Dogger Bank South Offshore Wind Farm

**Appendix H2 to the Natural England Deadline 2 Submission**  
**Natural England's comments and advice on Offshore Ornithology Compensation**

Planning Inspectorate Reference EN010125

27<sup>th</sup> February 2025

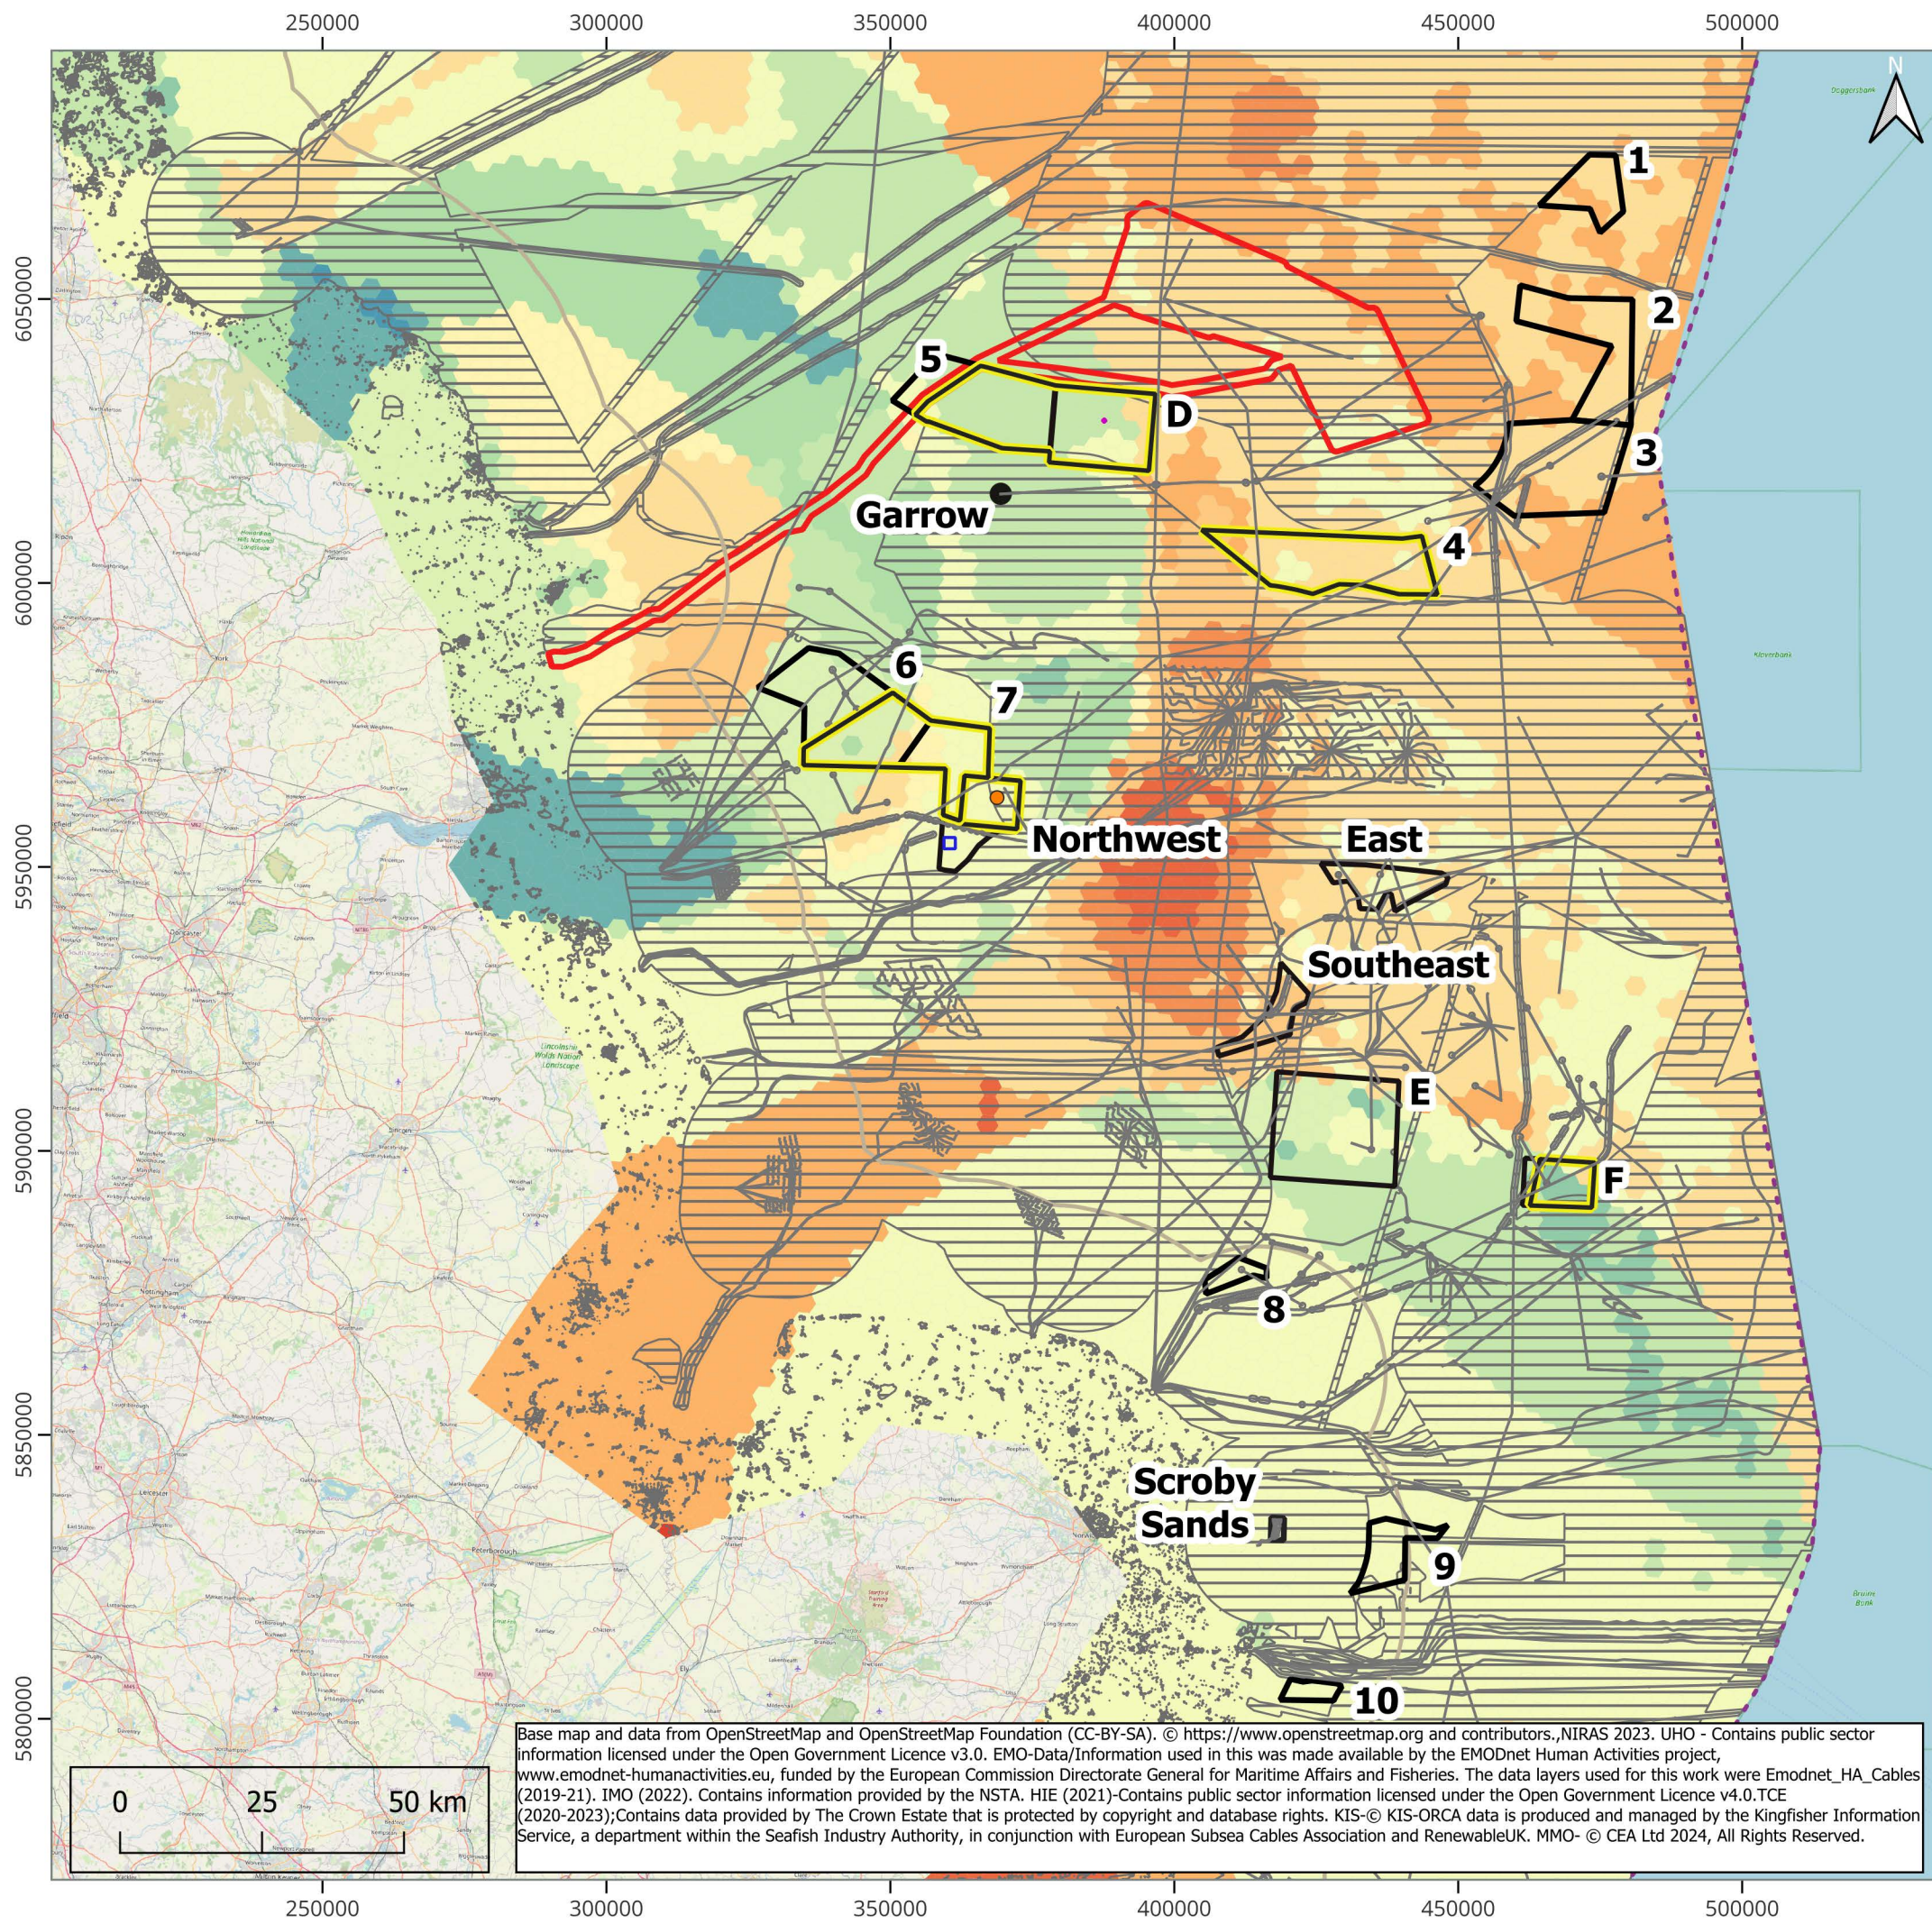
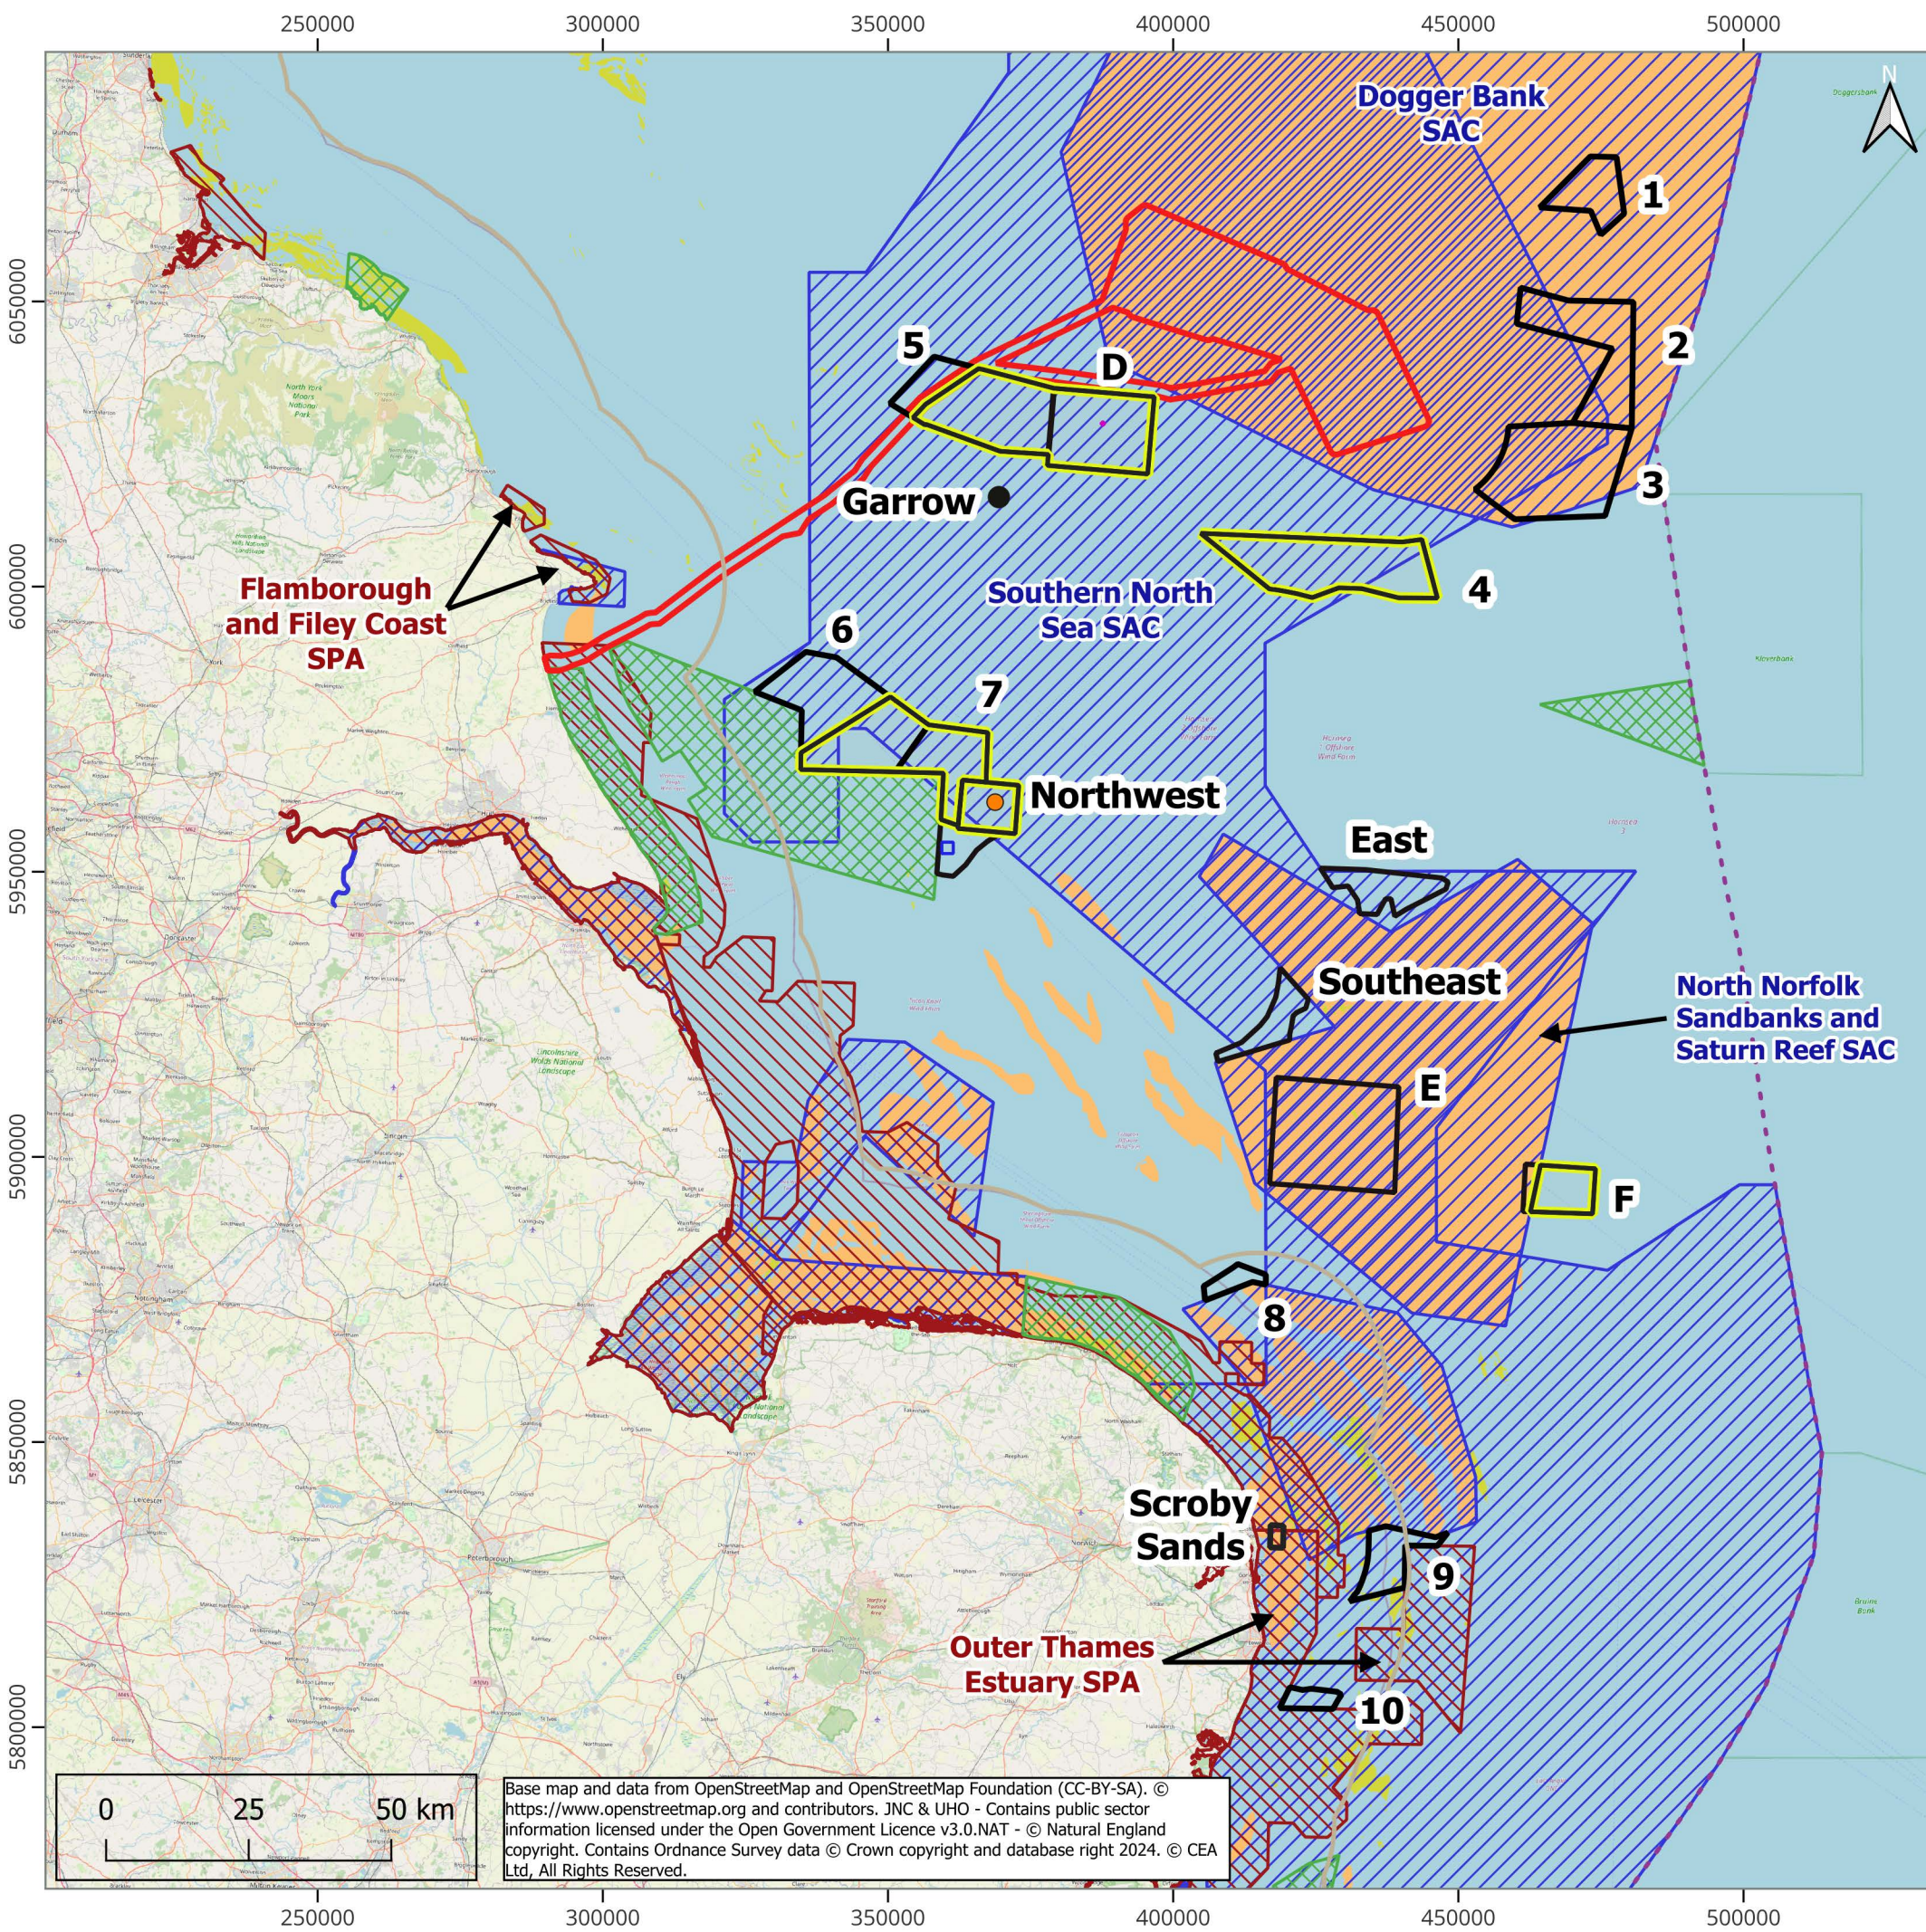
- Site F - We welcome that the area that overlapped with the North Norfolk Sandbanks and Saturn Reef (NNSSR) SAC has been removed from the Area of Search.
- Sites 4 and 5 - As per our Relevant Representations advice, we highlight that these sites appear to be within the buffer zones for DBS and the Hornsea Zone offshore wind farms (OWF). Consideration should be given to a greater degree of collision risk for a colony established here.
- 6, 7 & North-West - These locations are not as far inshore as the original 'West' location, however consideration should still be given to the likelihood of competition with birds foraging from FFC SPA. We advise the Project to look into any overlap with these areas in available kittiwake utilisation distribution maps (e.g. Cleasby et al. 2020, Waggitt et al. 2020). For site

6 it would also be beneficial to present the minimum distance to Flamborough Head, for consideration of the Yorkshire Wolds AONB.
